**Office of  
Environment  
& Heritage**

Our Ref: DOC16/536014  
Your Ref: s75W Saltwater

**Re: Modification to Residential Subdivision at Belle O'Connor Street, South West Rocks.**

Illustration 2.2      Northern APZ:

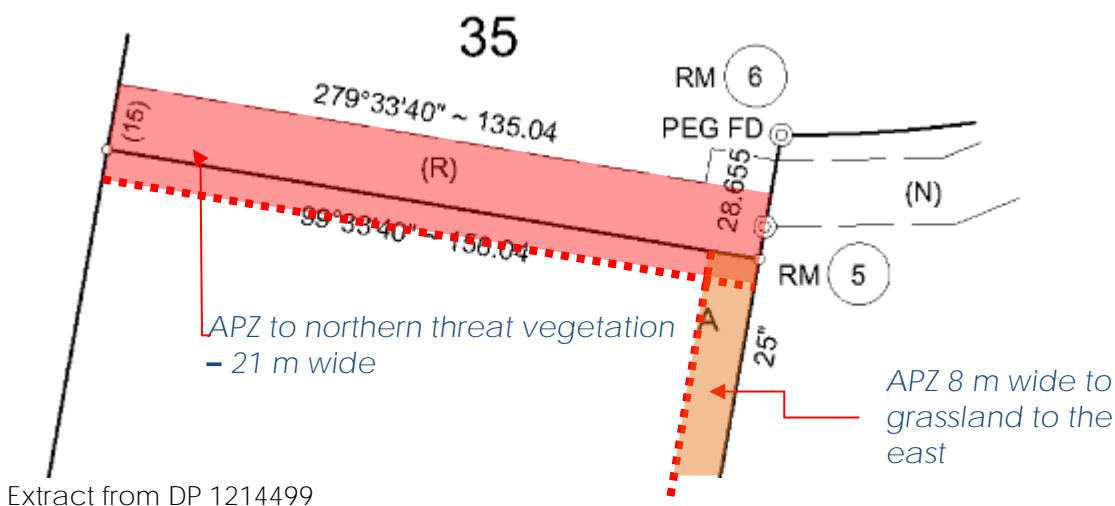
- f. The OEH also notes that the bushfire Asset Protection Zone (APZ) to the lots in the northern part of the subject land is depicted in the modification report as occurring on the neighbouring property to the north. It is unclear how an APZ restriction will be imposed on a neighbouring property. From the Director-General's Environmental Assessment Report dated May 2011 it appears that the neighbouring property to the north is zoned as environmental protection (7(b)). An APZ would not be appropriate in such a zoning.

- 1. An appropriate biodiversity offset should be determined and secured as part of the proposed modification.
- 2. All bushfire Asset Protection Zones are to be contained within the subject property and should not impact on biodiversity values.
